**St. Catherine's School****Community Consultation Schedule***Rev 03**Last updated 18-08-2014***Summary of Consultation Events**

## 1. Meeting No. 1 – St. Catherine’s School Neighbours

BUILDING CONFIGURATION TO MINIMISE HEIGHT AND VOLUME

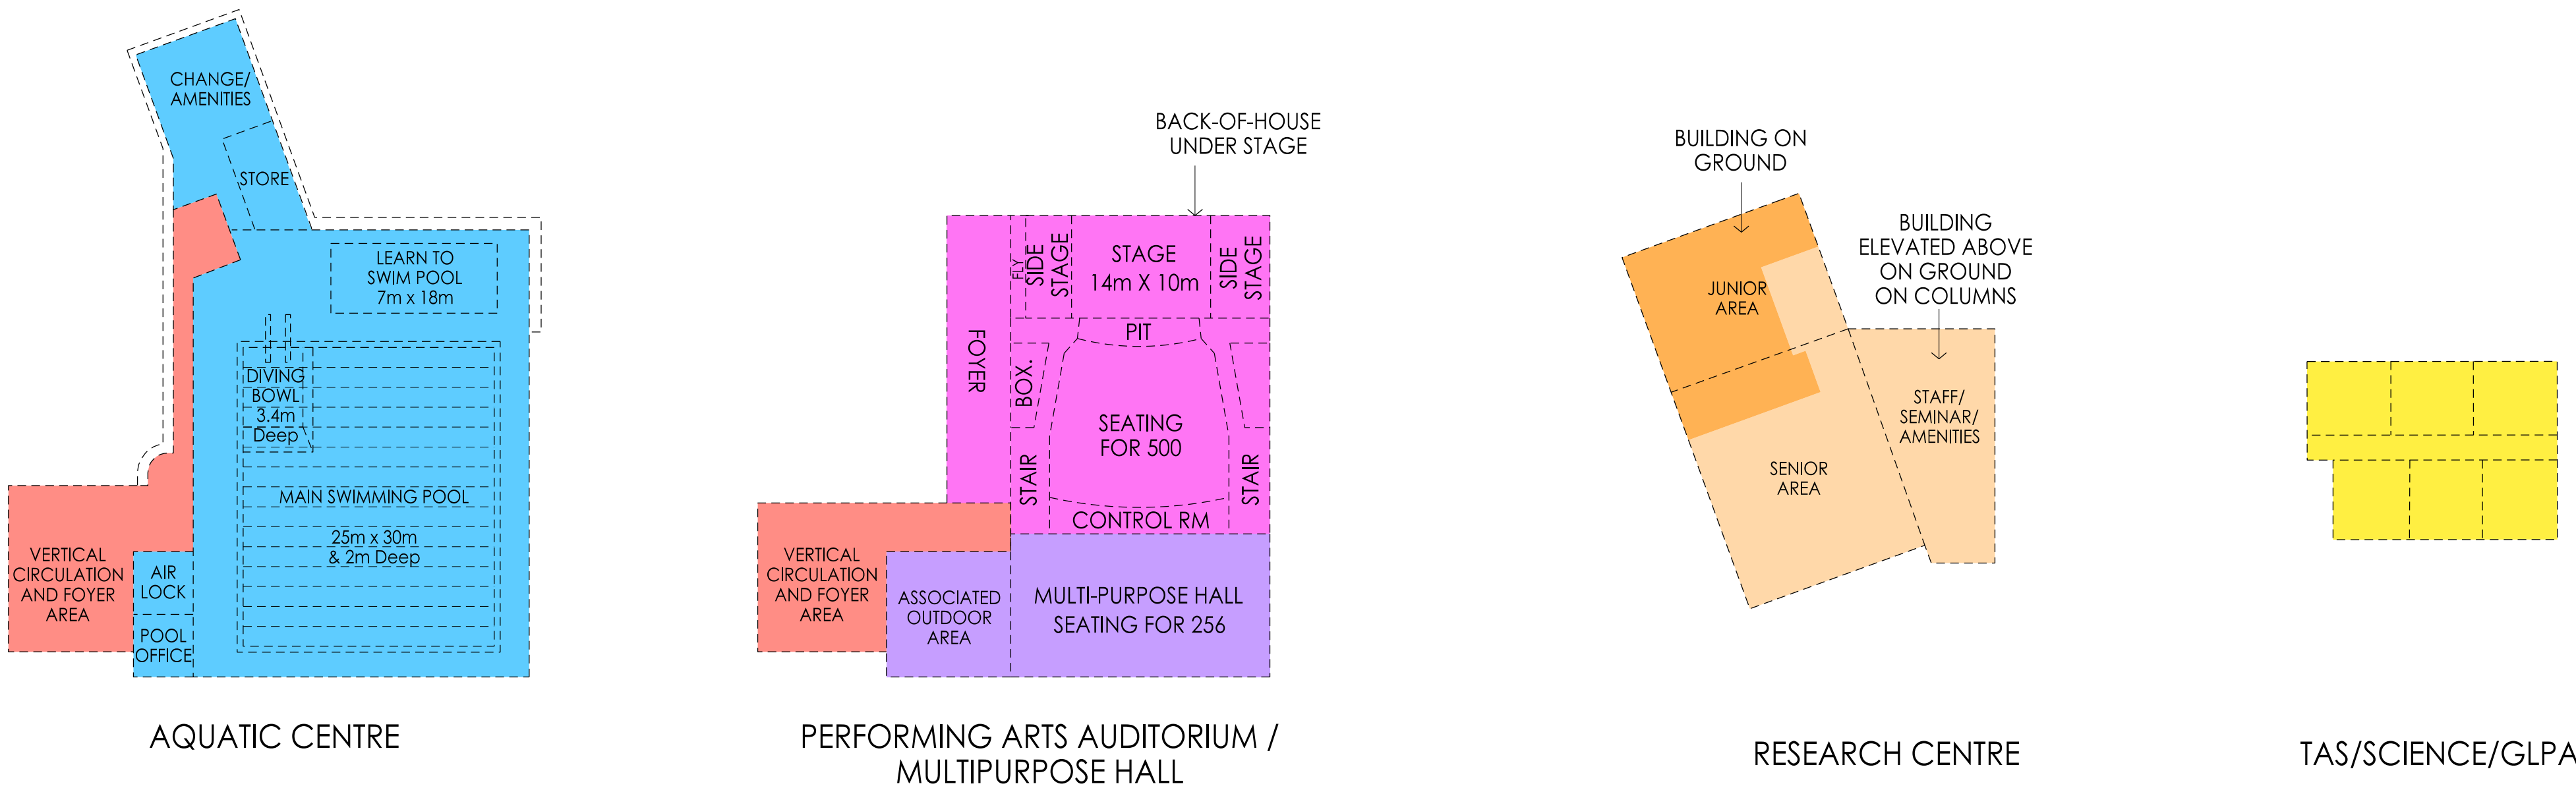
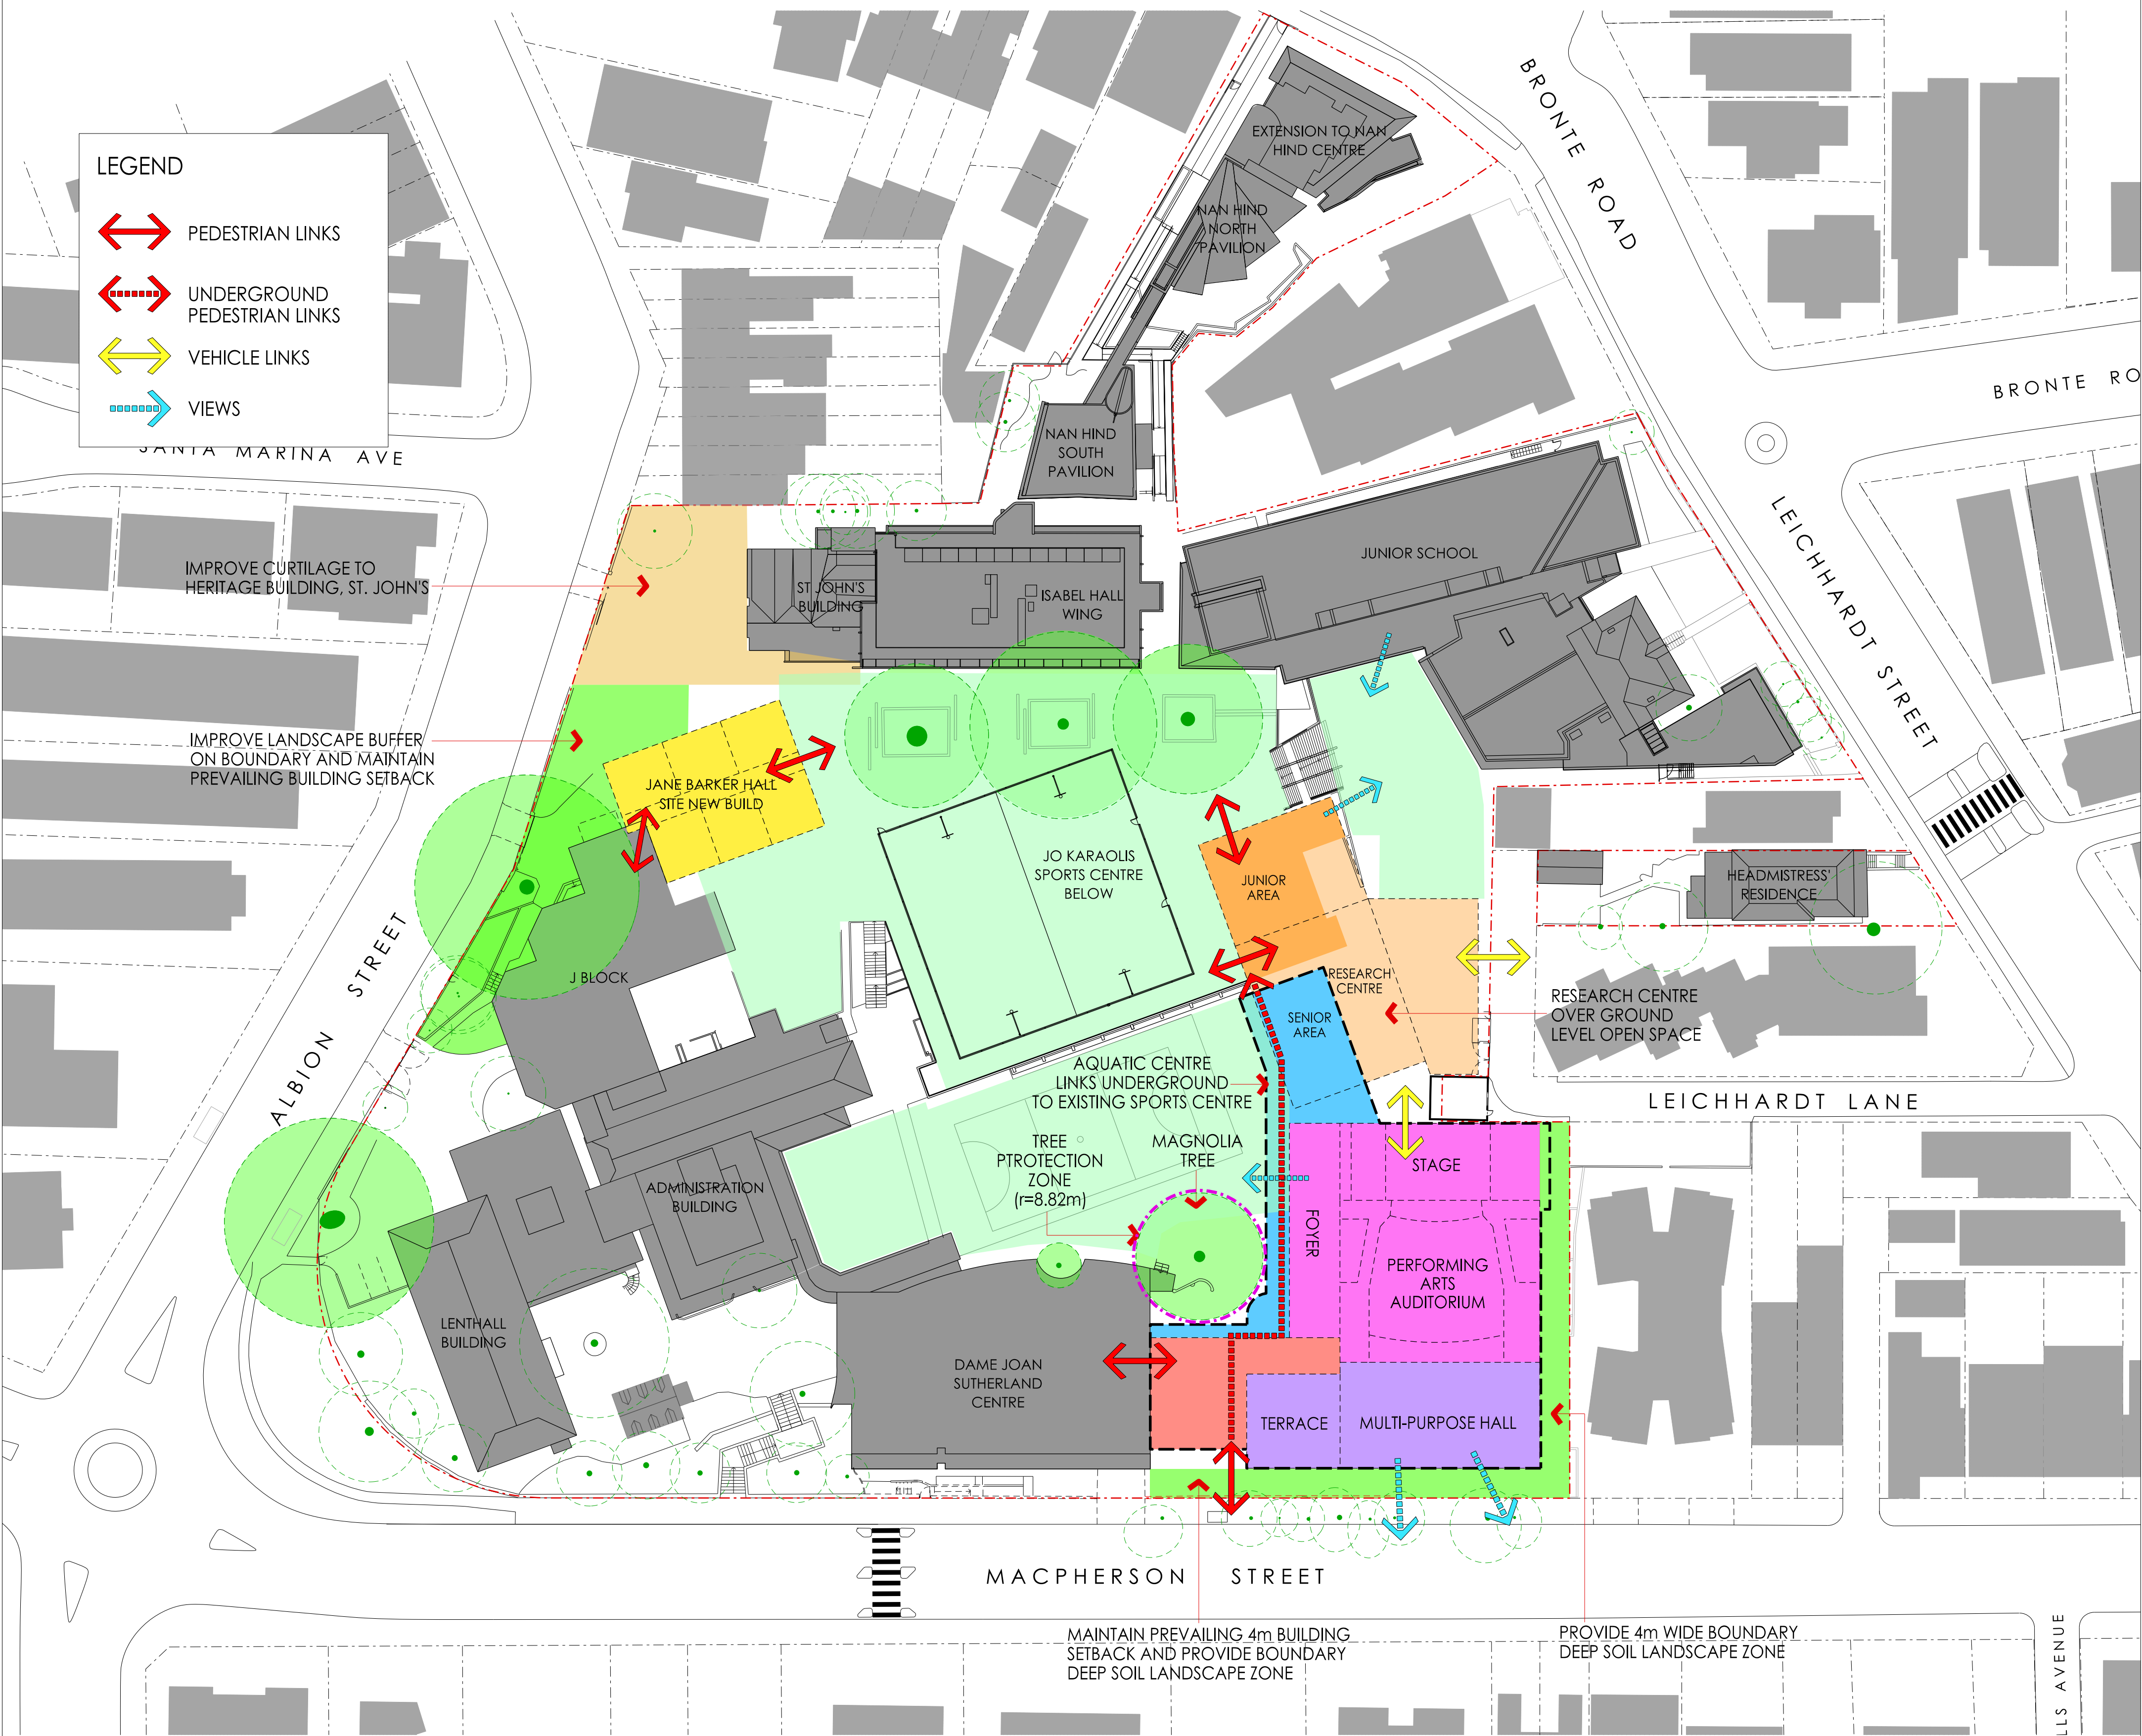
- ii. Solar impact of proposed RPAC development on No. 4 Macpherson St. – request to minimise bulk or increase setback from boundary.
- iii. Impact of proposed RPAC development on existing trees within development footprint (i.e. street trees) – request to clarify extent of tree removal.

- ii. Building bulk has been addressed through the reduction in the overall building massing of RPAC. Refer to *Design Evolution Diagram* prepared by Mayoh Architects. The perceived height and bulk of the building as viewed from the East has also been reduced. Specifically, the Eastern façade of RPAC has been further articulated through the use of different external materials, eliminating any large extents of the one building material. A “Green screen” has also been added at high level, and a substantial landscape area created at low level, to create different “layers” of landscape as viewed from the East. This façade treatment will also reduce any potential reflectivity of external building materials.  
Refer also to shadow diagrams *A.MP.700 - A.MP.708 for potential shadow impacts*.

A.MP.042 A

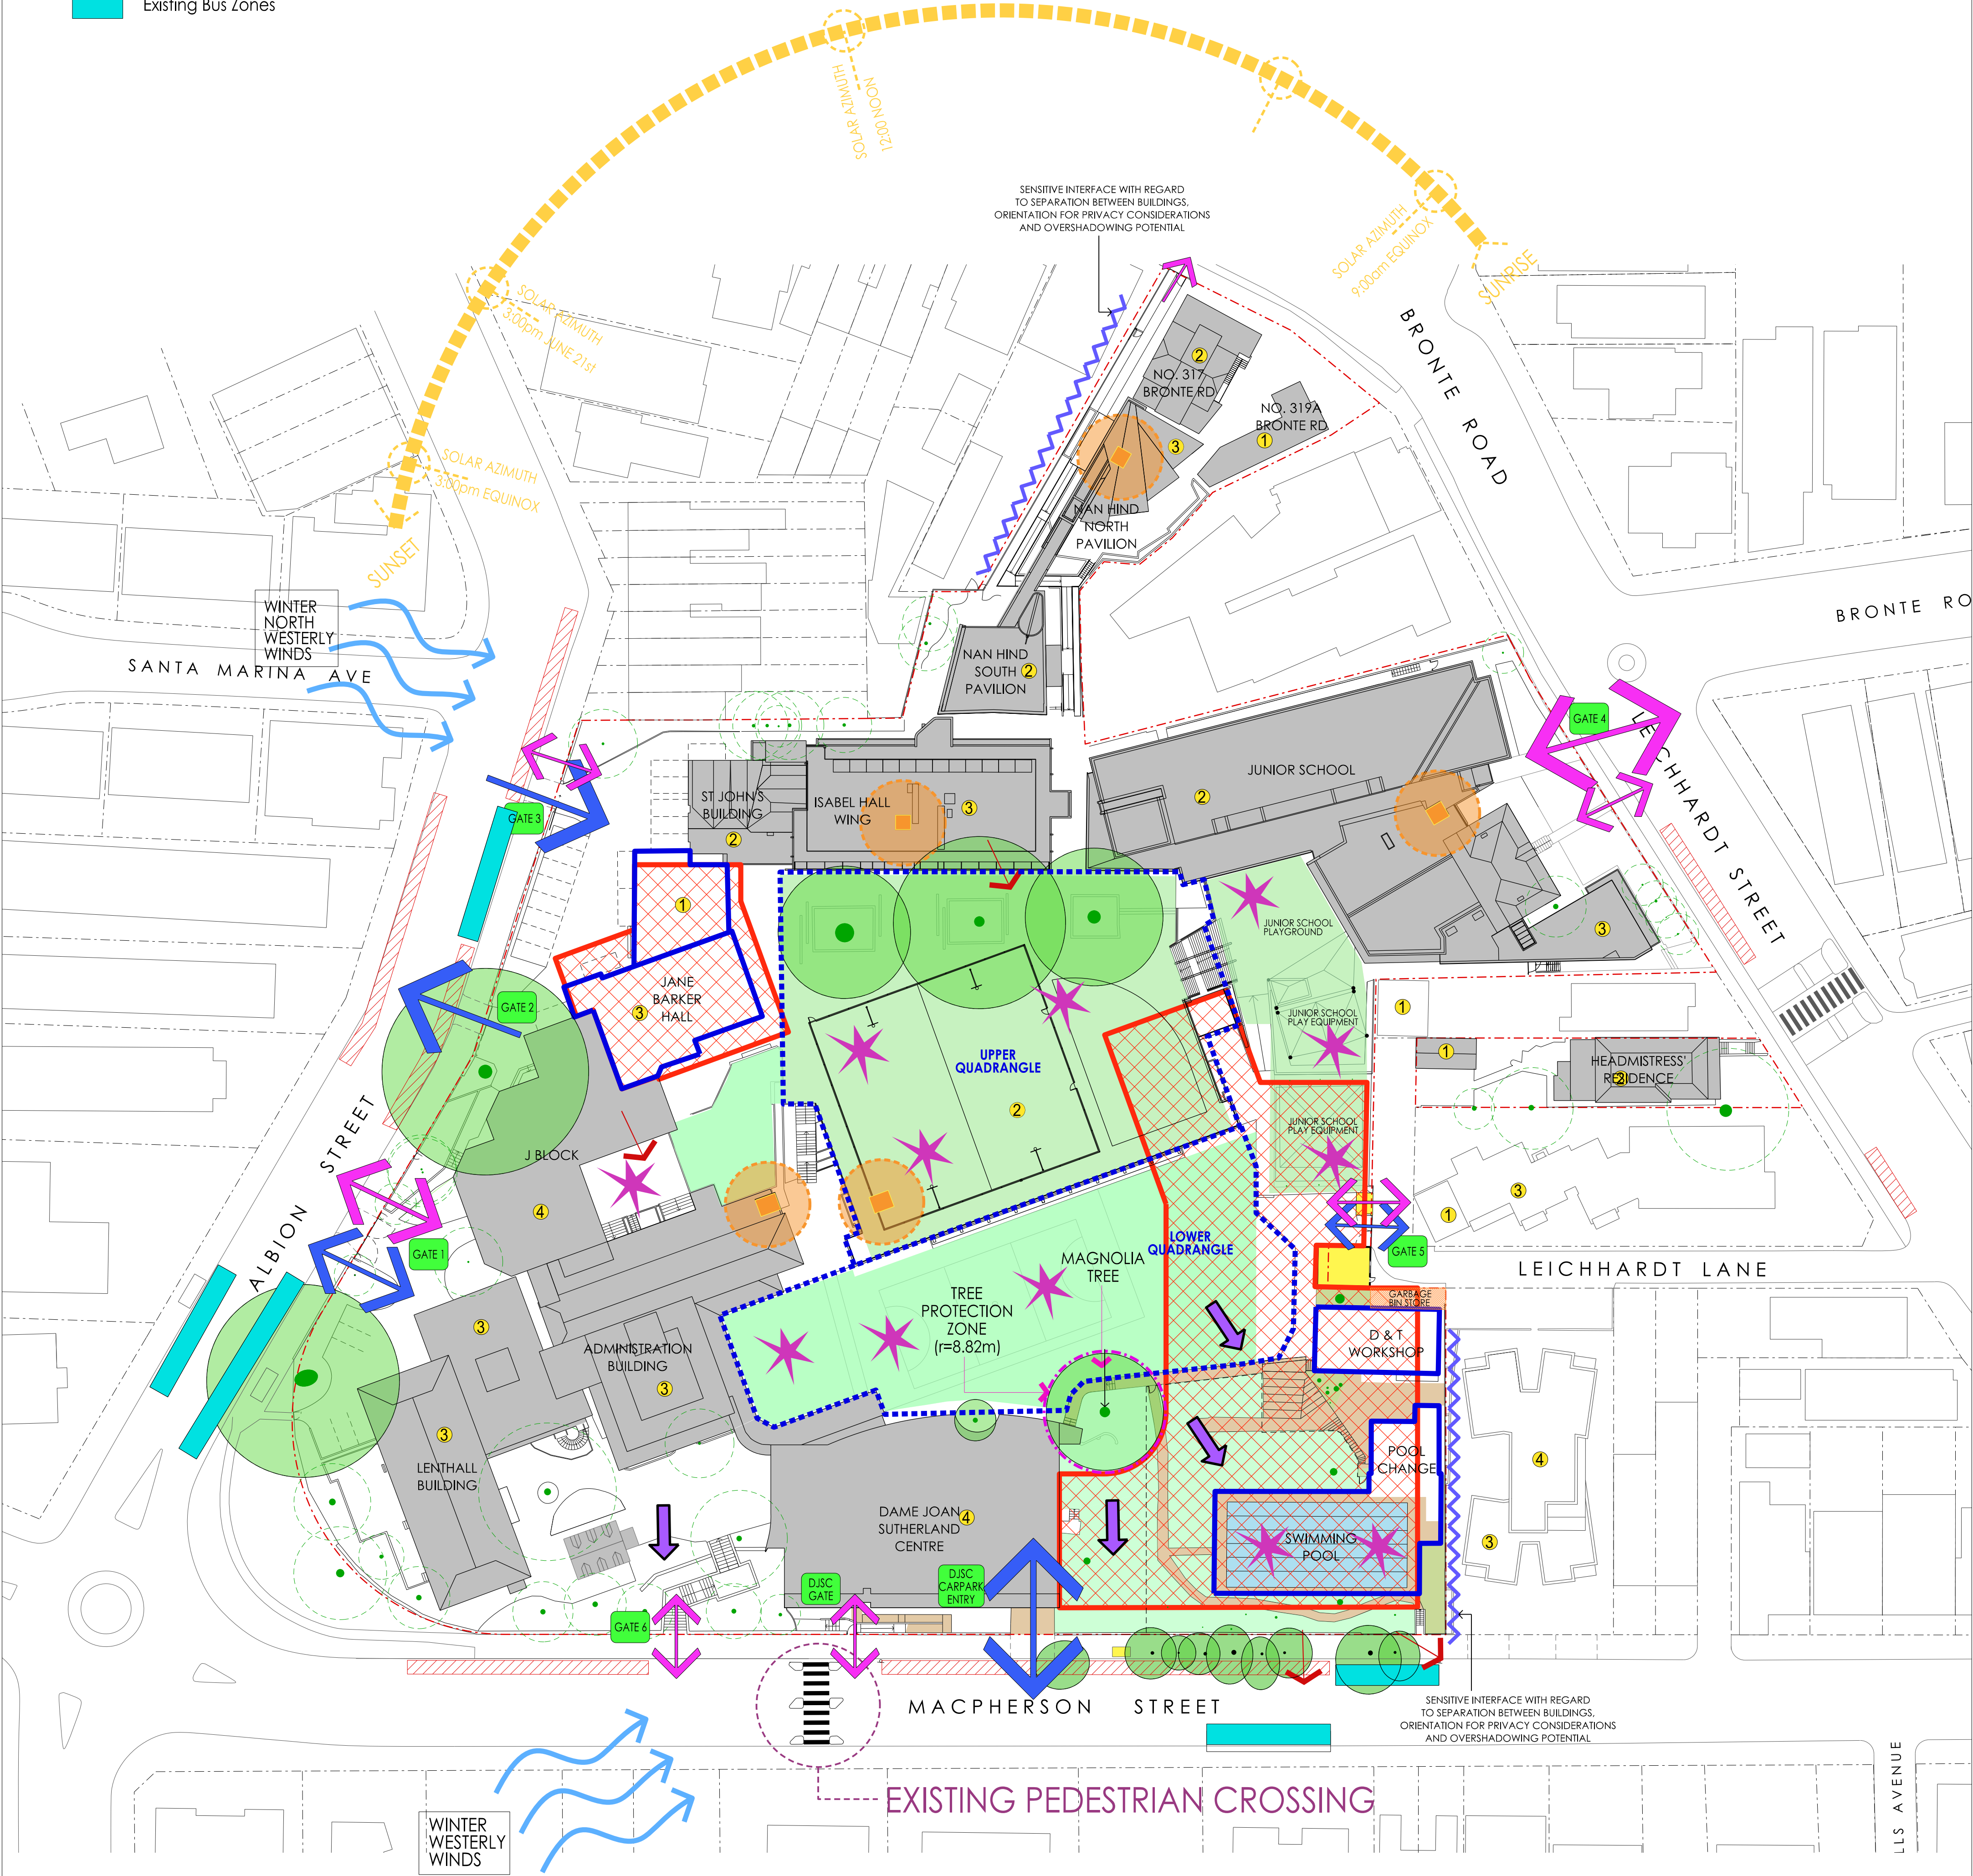
- i. Privacy, shadowing and building height
- ii. Tree removal
- iii. Traffic management of new facilities
- iv. Waste collection
- v. Services access
- vi. Traffic and parking during construction
- vii. Upgrade of bus shelter on corner of Albion St and Macpherson St
- viii. Public access and proposed use of new facilities

- a. Key issues/concerns raised:
  - i. Privacy, shadowing and building height
- b. Design response/justification:
  - i. Privacy has been addressed through the following measures:

- Shadowing has been addressed in Architectural Drawings A.MP.700 - A.MP.708 (RPAC) and A.MP.040 – A.MP.042 (Jane Barker Hall).
    - Building height has been addressed through the reduction in the overall building massing of RPAC. Refer to Design Evolution Diagram prepared by Mayoh Architects. The perceived height and bulk of the building as viewed from the East has also been reduced. Specifically, the Eastern façade of RPAC has been further articulated through the use of different external materials, eliminating any large extents of the one building material. A “Green screen” has also been added at high level, and a substantial landscape area created at low level, to create different “layers” of landscape as viewed from the East. This façade treatment will also reduce any potential reflectivity of external building materials.

- Shadowing has been addressed in Architectural Drawings A.MP.700 - A.MP.708 (RPAC) and A.MP.040 – A.MP.042 (Jane Barker Hall).
      - Building height has been addressed through the reduction in the overall building massing of RPAC. Refer to Design Evolution Diagram prepared by Mayoh Architects. The perceived height and bulk of the building as viewed from the East has also been reduced. Specifically, the Eastern façade of RPAC has been further articulated through the use of different external materials, eliminating any large extents of the one building material. A "Green screen" has also been added at high level, and a substantial landscape area created at low level, to create different "layers" of landscape as viewed from the East. This façade treatment will also reduce any potential reflectivity of external building materials.
